Office of
Environment
& Heritage

Our Ref: DOC19/383085
Your Ref: MP 06_0143 MOD 4

Re: Glades Estate Residential Subdivision (MP 06_0143 MOD 4)

Attachment 1: Detailed OEH Comments – Glades Estate Residential Subdivision (MP 06_0143 MOD 4)

DRAWING TITLE
1% AEP CATCHMENT + 5% AEP OCEAN + CLIMATE CHANGE
PROPOSED CONDITION
WATER LEVEL (mAHD) & WATER DEPTH (m)

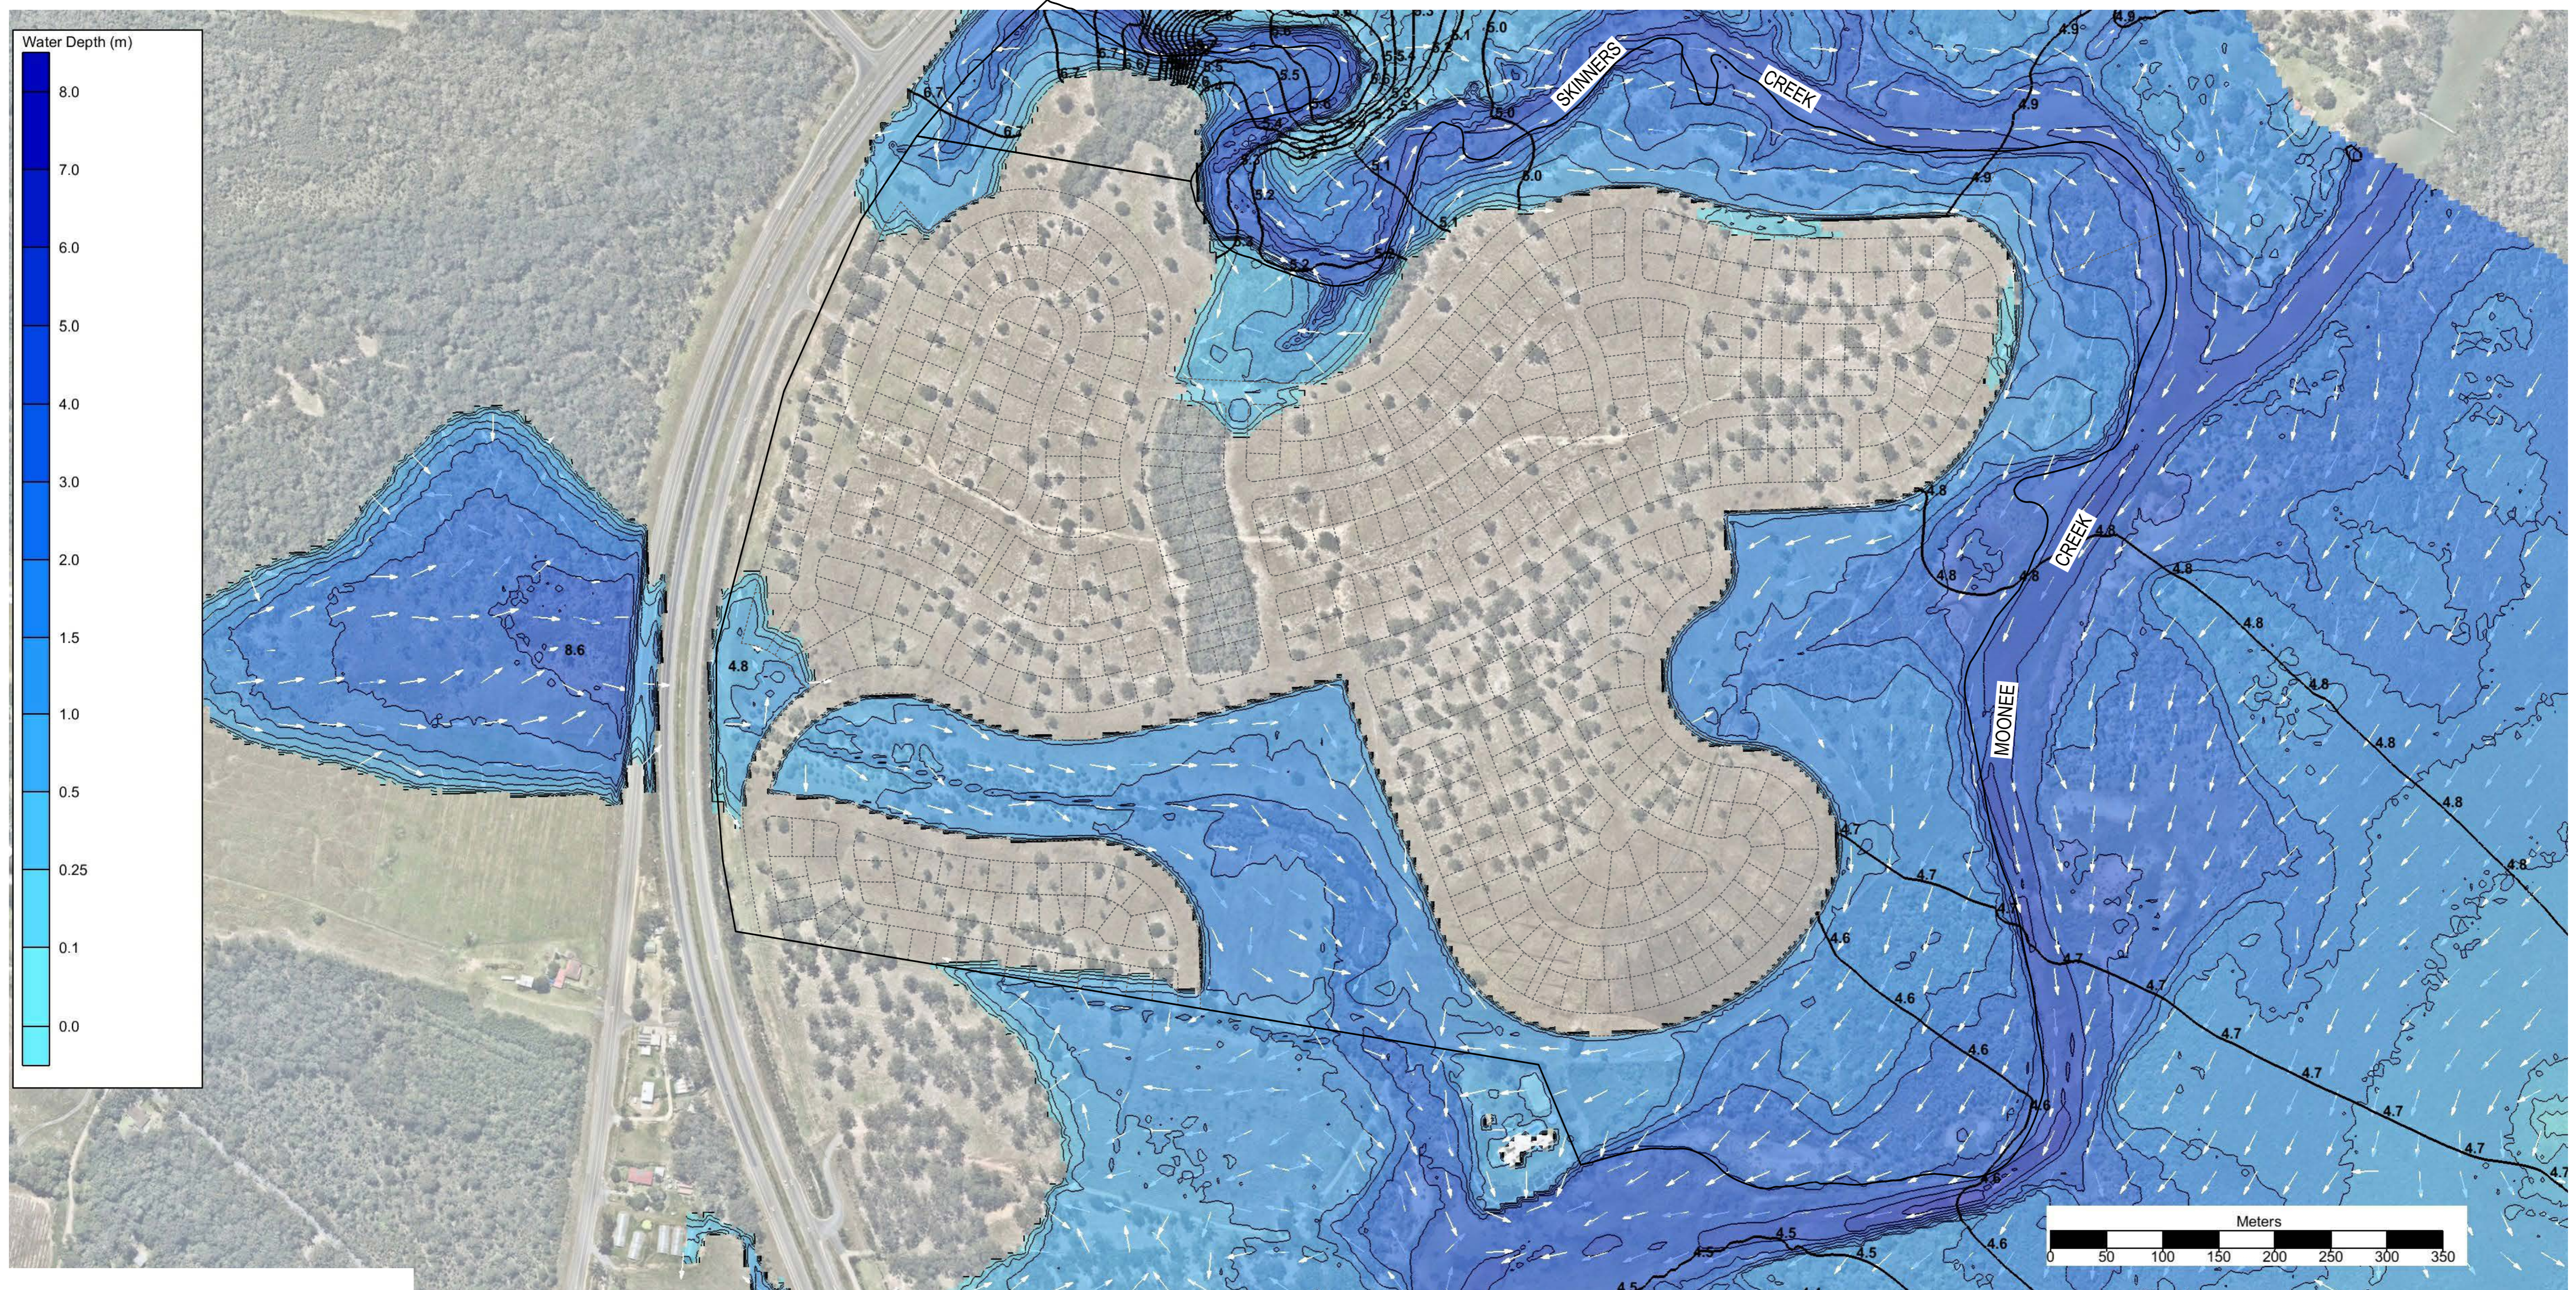
The flood assessment models 1%, 5% AEP and PMF flood events in various combinations of rainfall and tailwater level. The results are consistent with existing flood modelling and modelling undertaken for adjoining development areas. Impacts of climate change have also been modelled for the 1% AEP flood with a 10% increase in rainfall and 0.9m increase in tailwater level (scenario 5 in the flood assessment) with a predicted flood level varying between 3.5 - 4.2m AHD for the site.

The proposed development should have residential lots and roads located above the 1% AEP climate change flood level. Stormwater treatment infrastructure, such as swales and basin, are to be located above the 5% AEP flood level.

- D6.1 All parts of residential lots suitable for dwellings and all residential roads are to be located above the '1% AEP Catchment + 5% AEP ocean + climate change' flood level in accordance with drawing PS01-K210 as per the Flood Assessment: The Glades Development, Lot 1 and 2 DP725785, Pacific Highway, Moonee Beach, NSW, Martens Consulting, January 2018. This is scenario five (5) in the flood assessment with a predicted flood level varying between 3.5 - 4.2m AHD for the site.
- D6.2 All stormwater treatment infrastructure such as swales and basin are to be located above the 5% AEP flood level.
